RE: File No. SUB17-004 - Lot Line Consolidation

This letter addresses the changes made to the above Lot Line Consolidation application based on comments received from your office in a letter of incompleteness dated April 10, 2017.

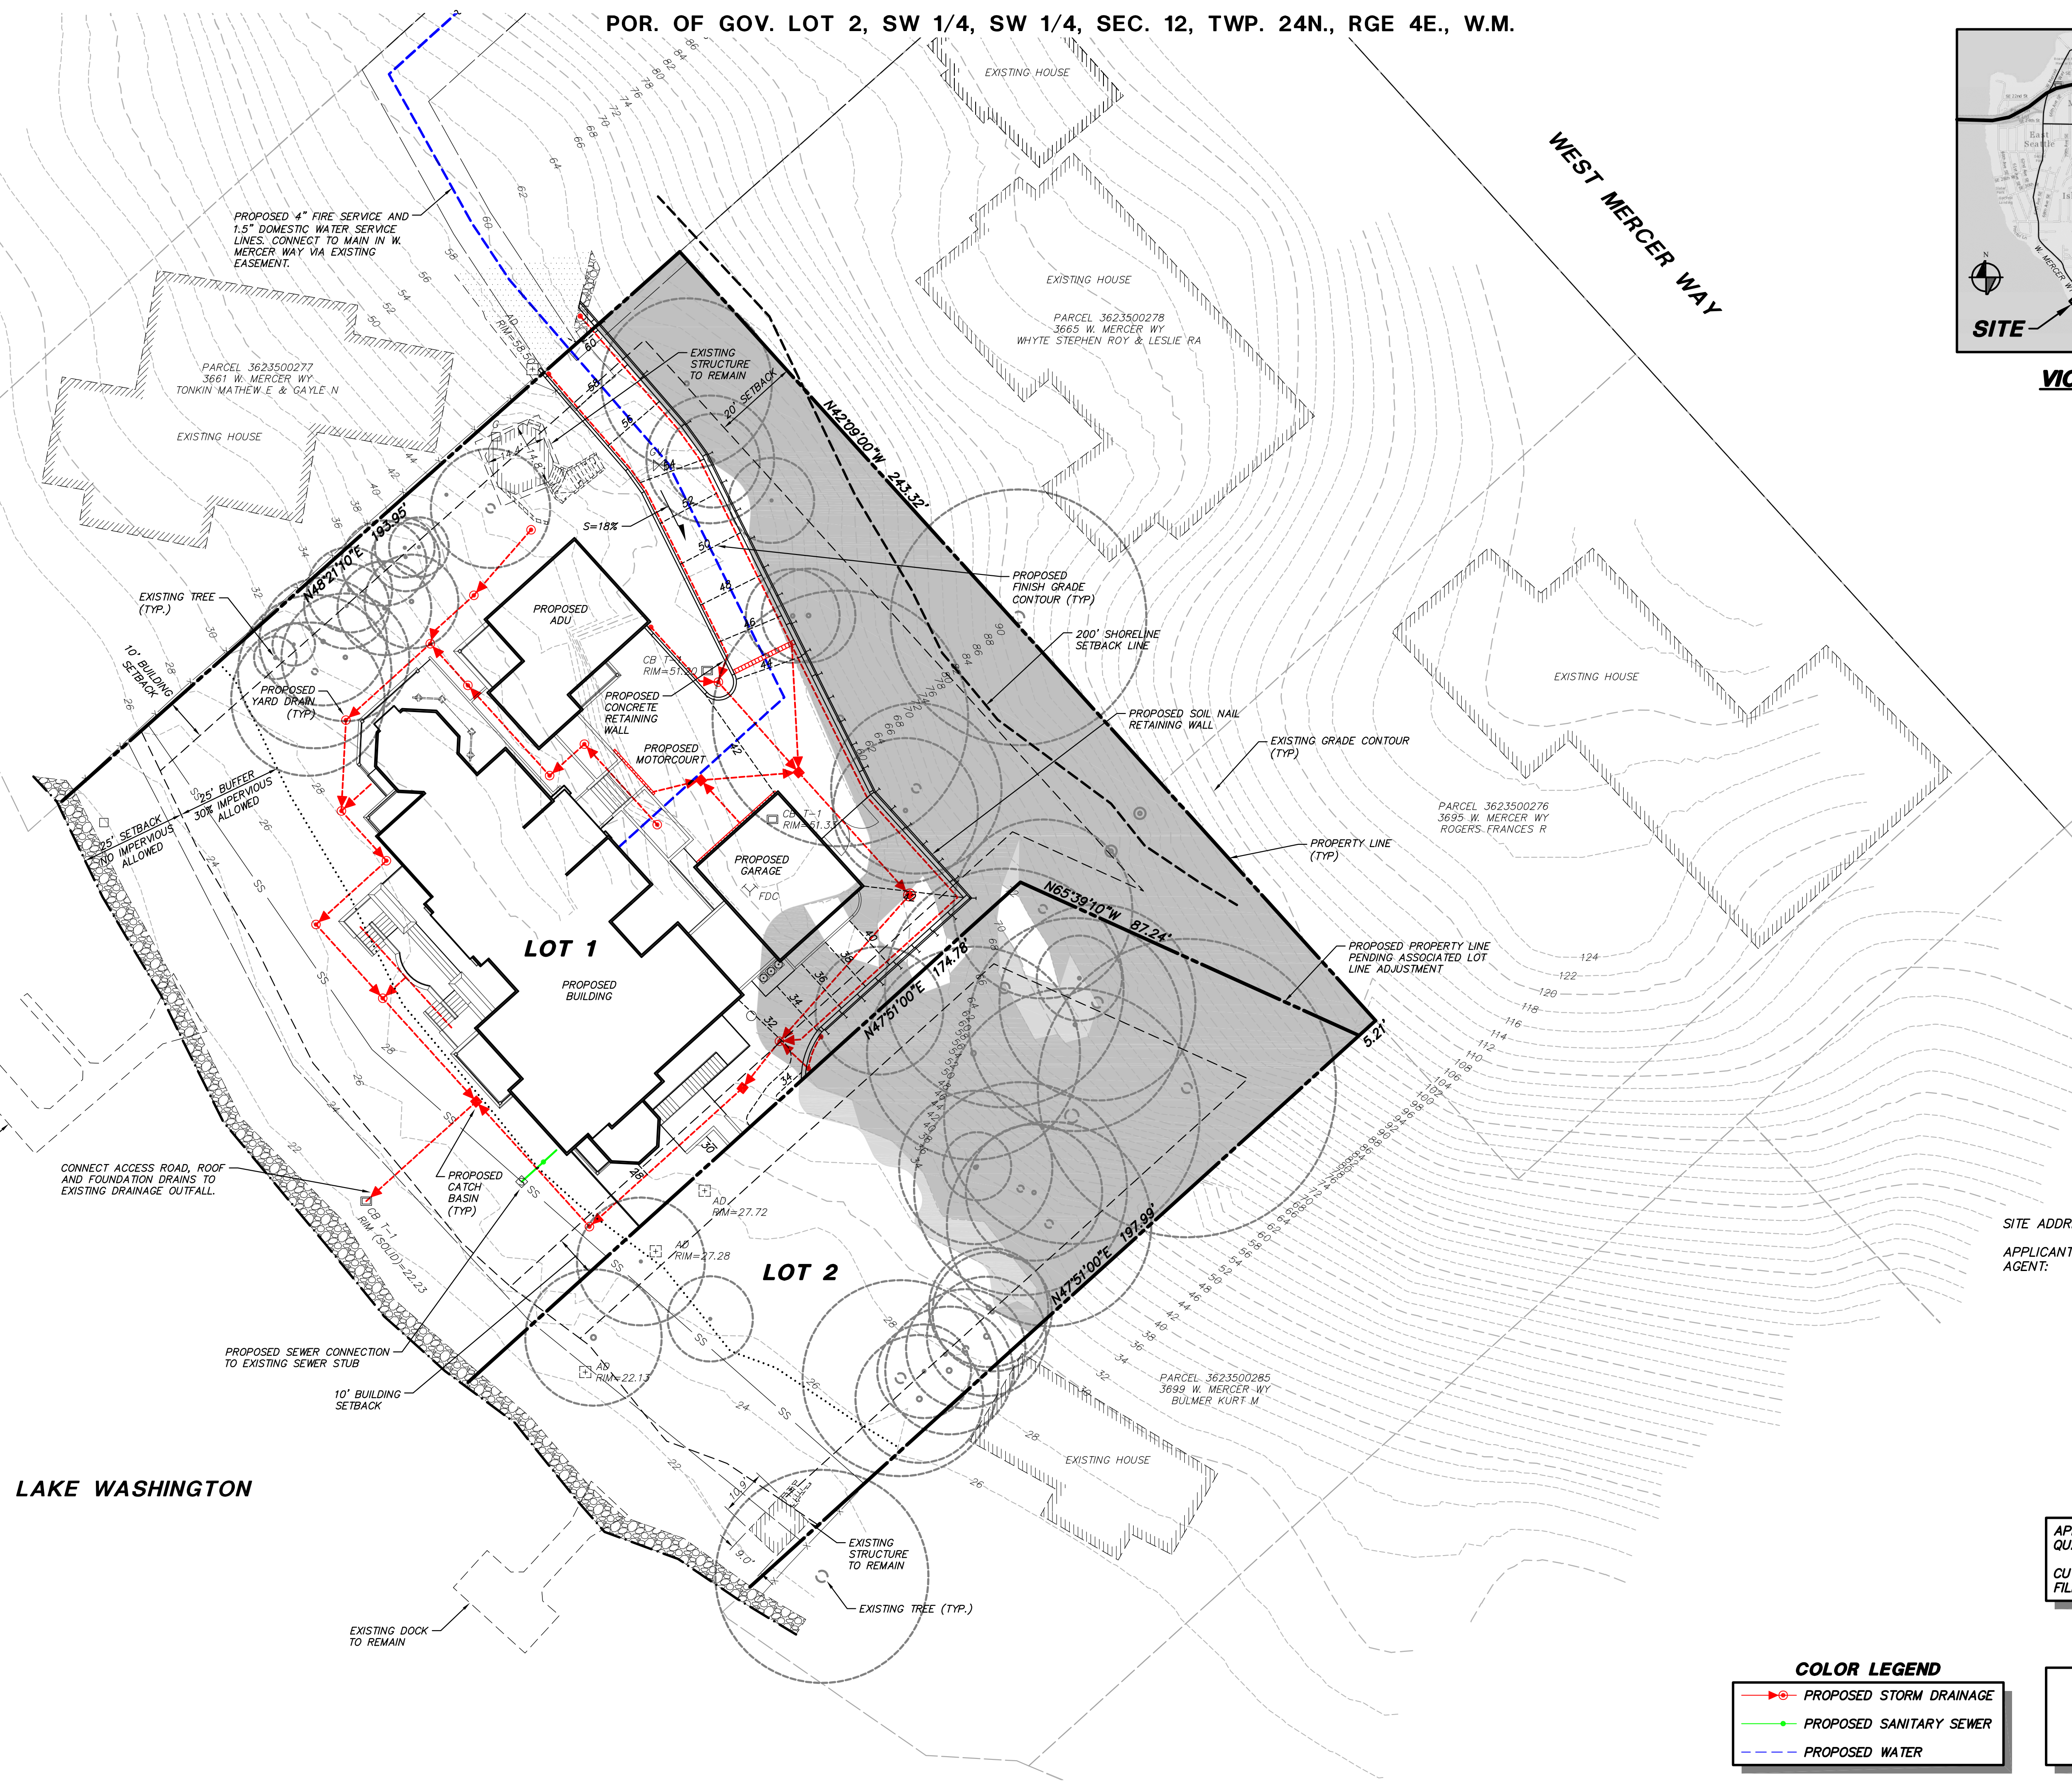
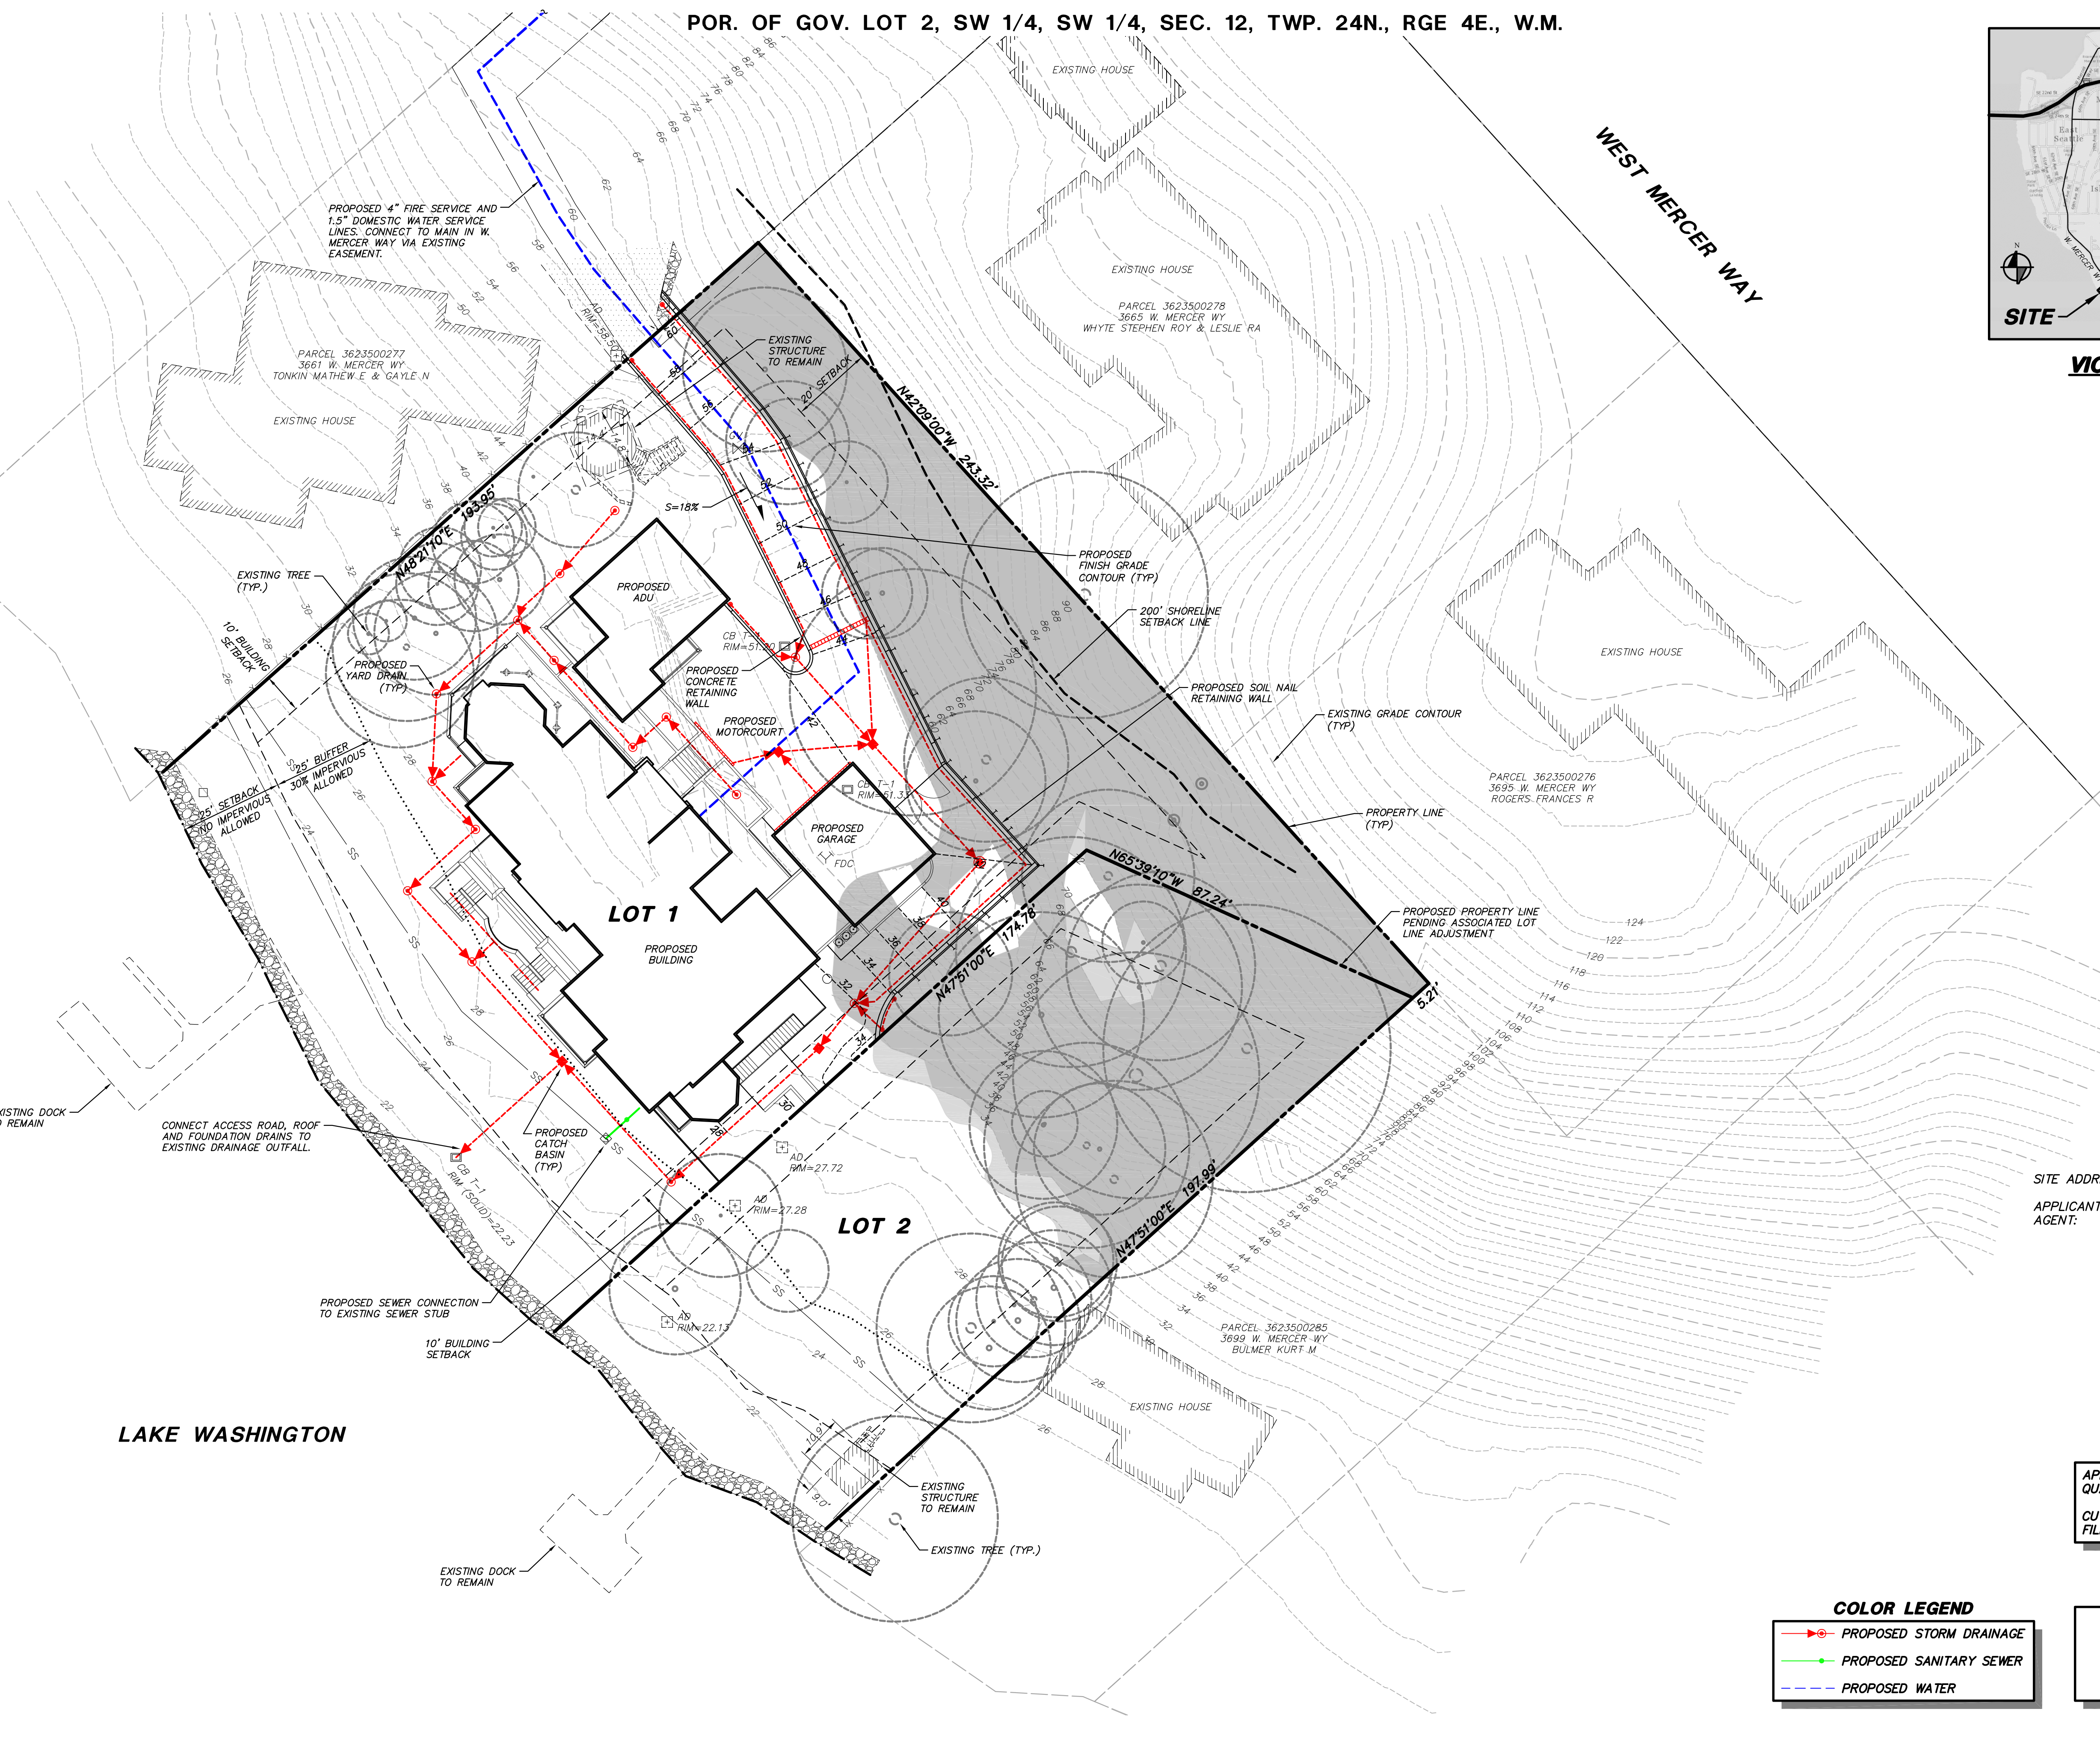
- 2) Please provide an additional site plan indicating the proposed development and the topographic lines with the steep slope indicated (hatching). Critical slopes exceeding 30 percent must be labeled and delineated by a clearly visible hatching. ***A site plan showing the steep slope analysis (steep slopes hatched and slopes over 30 percent hatched and shown in Slope Legend has been included in this upload to the City's ftp site for the above referenced SUB17-004.***

- 4) Please provide a conceptual grading plan. If the grade differential on the site of the proposed project will exceed 24 inches and/or if the amount of earth to be disturbed exceeds 50 cubic yards, the applicant shall provide copies of a detailed grading plan drawn by a Washington licensed engineer. ***A conceptual grading plan drawn up by a Washington licensed engineer has been included in this upload to the City's ftp site for the above referenced SUB17-004.***

- 5) Please provide a conceptual utility plan showing the locations of existing and proposed utilities. ***A conceptual utility plan drawn up by a Washington licensed engineer has been included in this upload to the City's ftp site for the above referenced SUB17-004.***
